Lower Thames Crossing

9.181 Final Statement of Common Ground between (1) National Highways and (2) Stuart Mee & Family (Tracked changes version)

DATE: December, 2023
DEADLINE: 9A

Planning Inspectorate Scheme Ref: TR010032
Examination Document Ref: TR010032/EXAM/9.181

PLAN 1

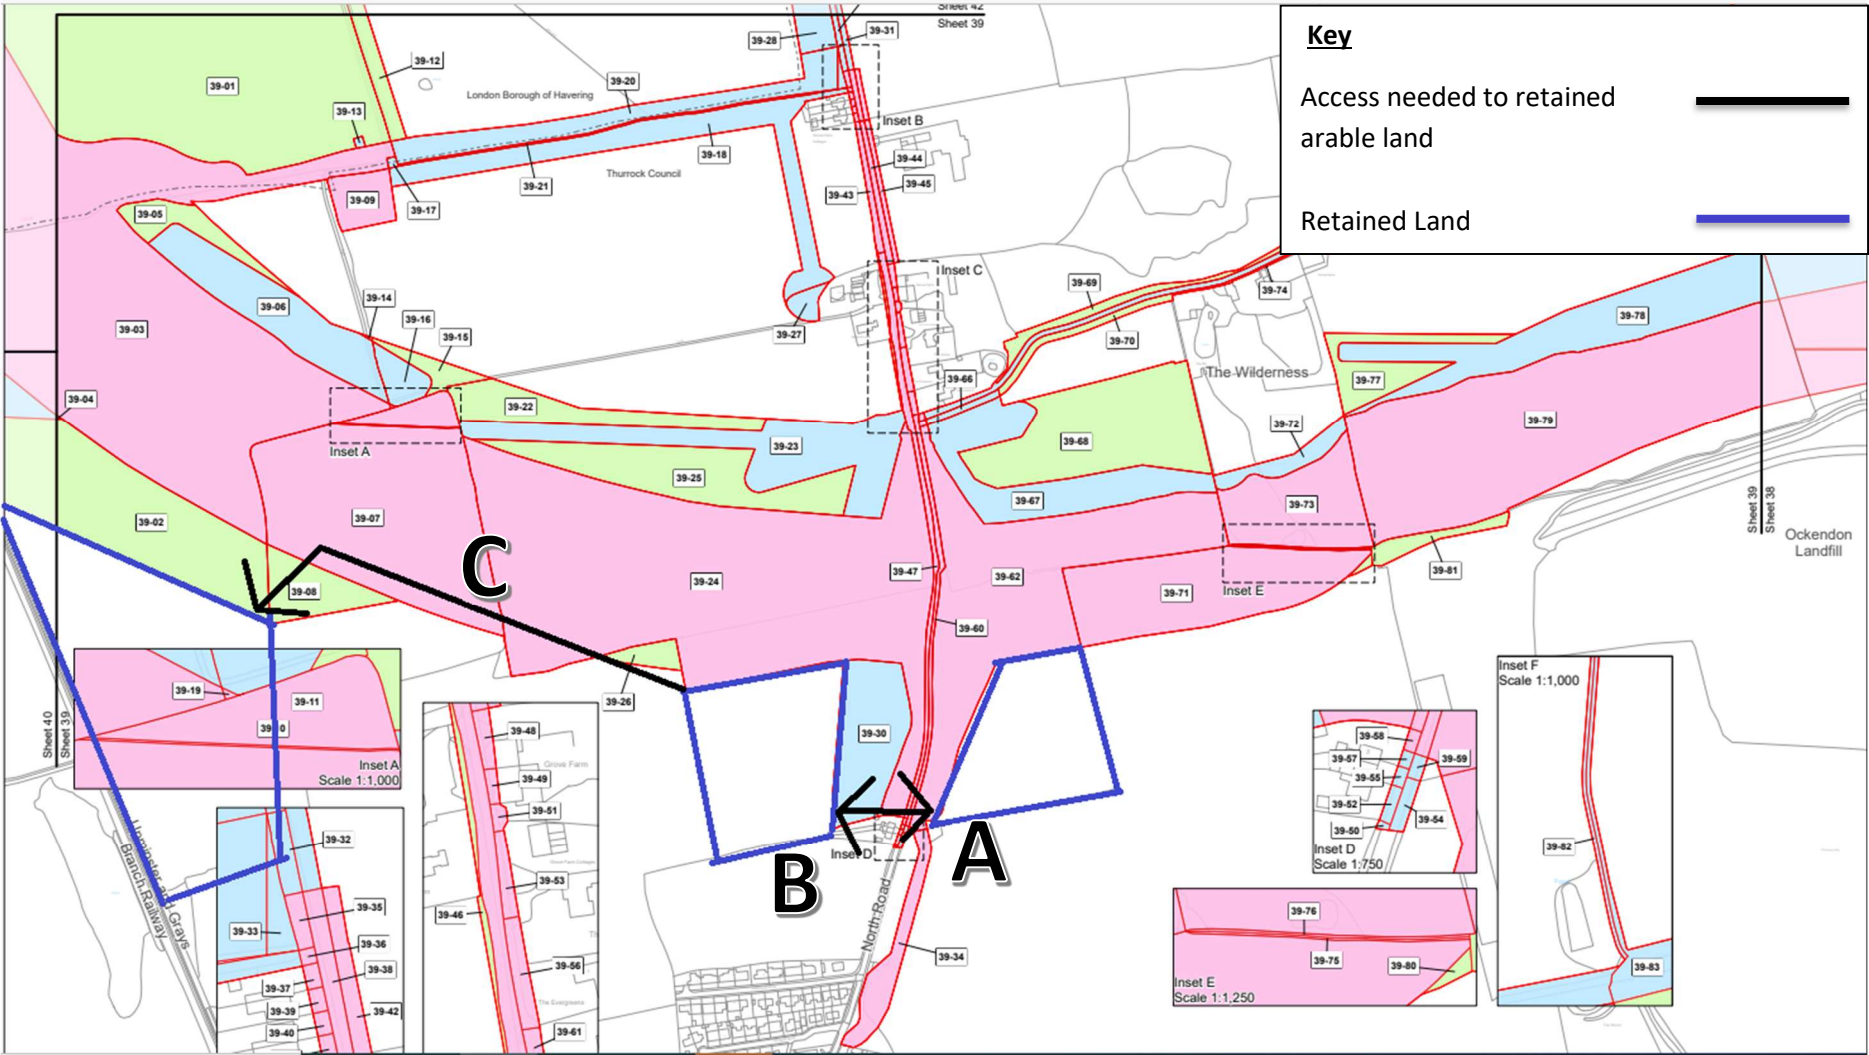
Topic	Item number	Stuart Mee & Family comment (Landowner)	The Applicant's response	Document Reference	Status
		<p>LTC alignment. The irrigation line where it crosses the M25 is illustrated in Plan 1</p> <p>The Landowner has commissioned a specialist water consultant to appraise the predicted impact and possible solutions to provide a viable and suitable alternative system.</p> <p>Understanding what the Applicant is proposing is a specialist piece of work and therefore they need their own Expert in this area. An options report has been sent to the applicant for review and the landowner requests feedback before Deadline 5.</p> <p>The Landowner is encouraged that both parties are finding a solution however, there is concern that there is an unknown on the water flow and levels as a result of the construction of LTC and the Landowner therefore reserves the right for compensation.</p> <p>The Landowner needs this to form part of a protective provision or side legal agreement.</p>	<p>in December 2022 along with an associated rain gauge.</p> <p>The landowner's consultant has provided <u>the Manor Farm Options Report and Manor Farm Options Summary</u> to the Applicant on 20 July 2023 <u>and November 2023 (respectively)</u> which <u>are</u> being reviewed. This will then help to inform a Preferred Option Development Report <u>in due course</u>, the Applicant <u>has committed to the above approach in both SACR-030 and also the draft</u> legal side agreement.</p>	<p><u>Commitments Register [Document Reference 7.21 (7)]</u></p>

PLAN 6

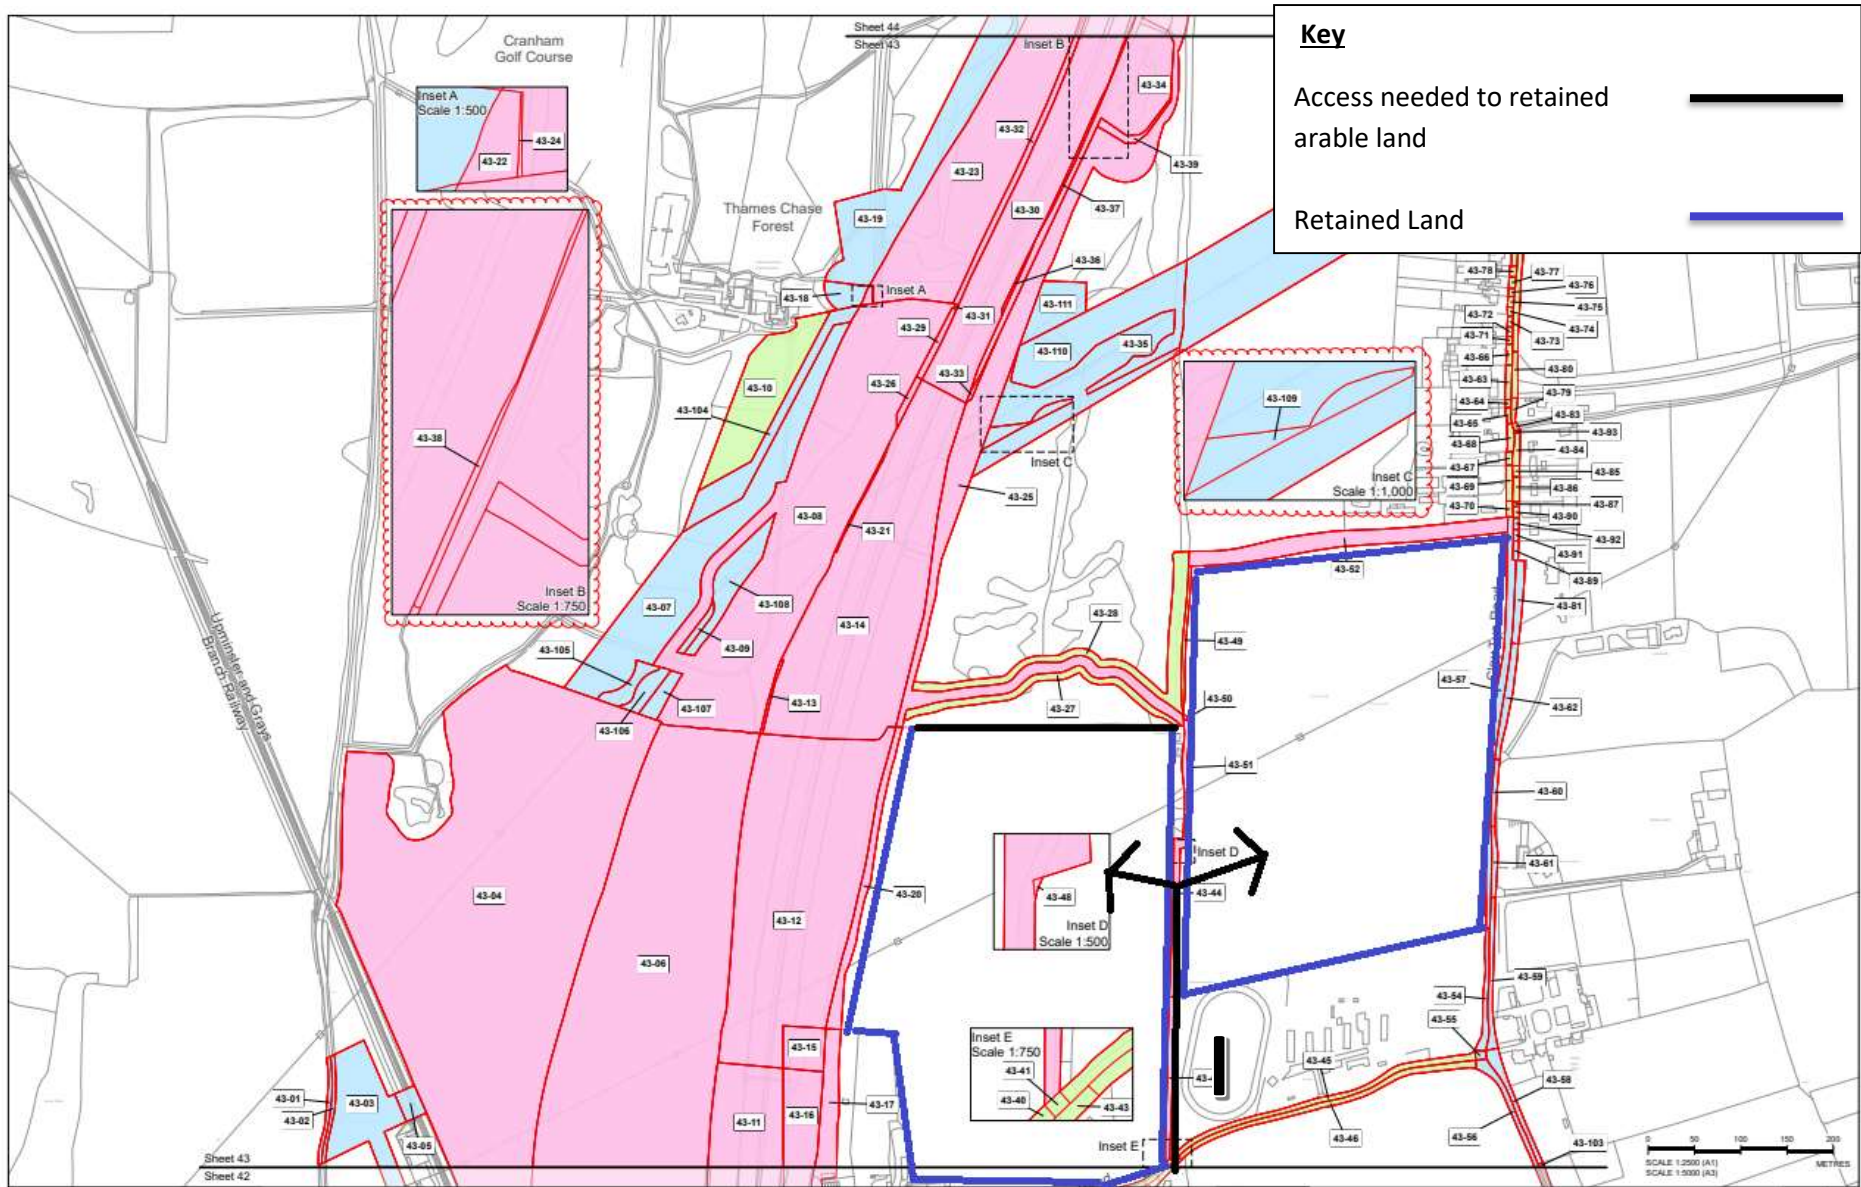
Topic	Item number	Stuart Mee & Family comment (Landowner)	The Applicant's response	Document Reference	Status
Land & Compulsory Acquisition					
Field Accesses	2.1.1	No detail has been provided around the field accesses to the landowners retained land indicated by black arrows into fields edged purple on the Plans 6-8 below in 2.2 Notes are of concern to the Landowner.	SACR-005 in the Stakeholder Actions and Commitments Register (SACR) commits the Contractor to maintain provision for farm access during the construction phase. The Applicant acknowledges the importance of maintaining /	<u>Stakeholder Actions and Commitments Register [Document Reference 7.21 (7)]</u>	Matter <u>Agreed*</u> , <u>Now secured under SACR-031 and also subject to the completion of the legal side</u>

PLAN 9

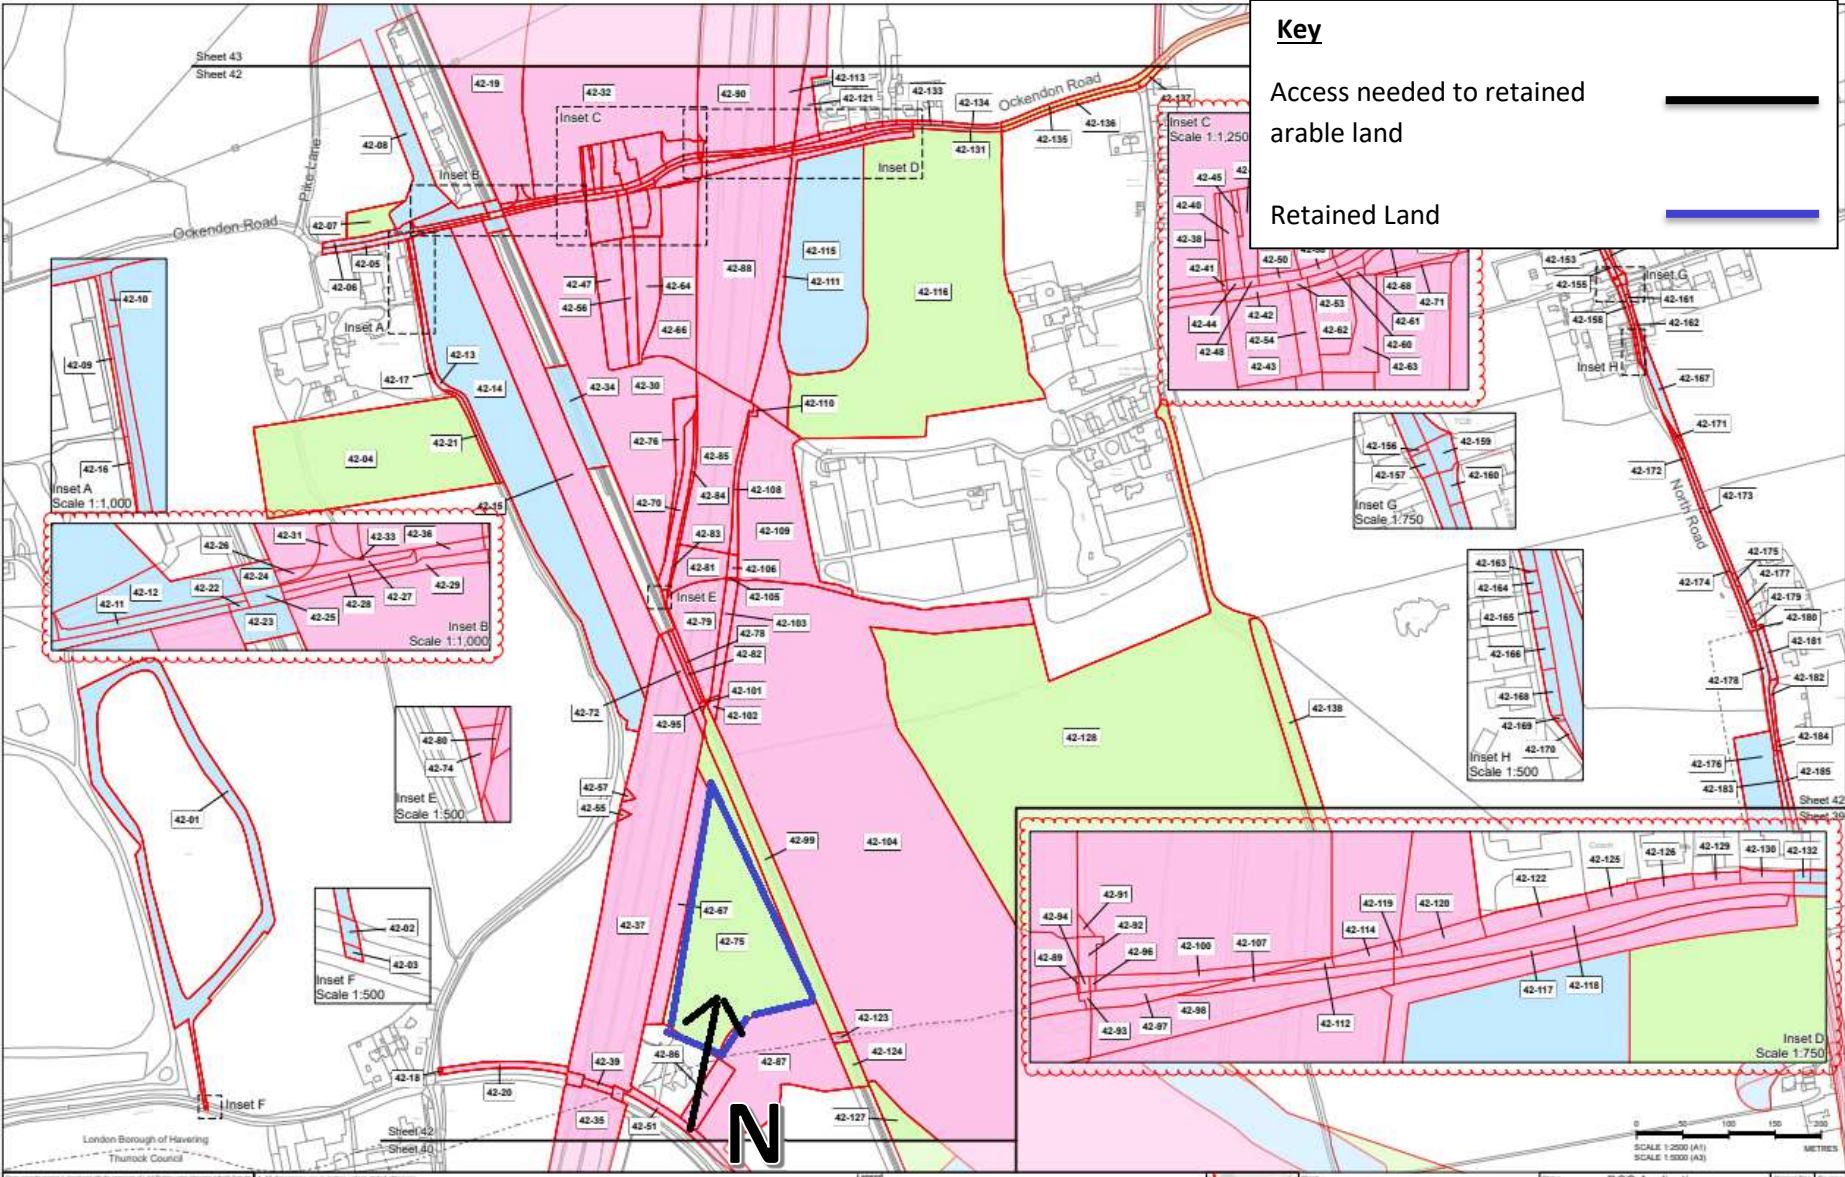
Access off Ockendon Road north across Plot 42-19 & Plot 43-04	2.1.2	<p>No detail has been provided around the field accesses indicated by black arrows into fields and pond edged purple on Plan 9 below in 2.2 Notes are of concern to the Landowner.</p> <p>The Contractors and National Highways (NH) requires a point of access from Ockendon Road which is</p>	<p>The Applicant <u>will transfer</u> the <u>Plots 42-19 and 43-04 to</u> Forestry England <u>and Essex County Council</u> as replacement open space land <u>subject to a permanent right of access from Pike Lane to Hobbs Hole Pond and from Ockendon</u></p>	<p><u>Stakeholder Actions and Commitments Register</u> <u>[Document Reference 7.21 (7)]</u></p>	<p>Matter <u>Agreed*</u></p>
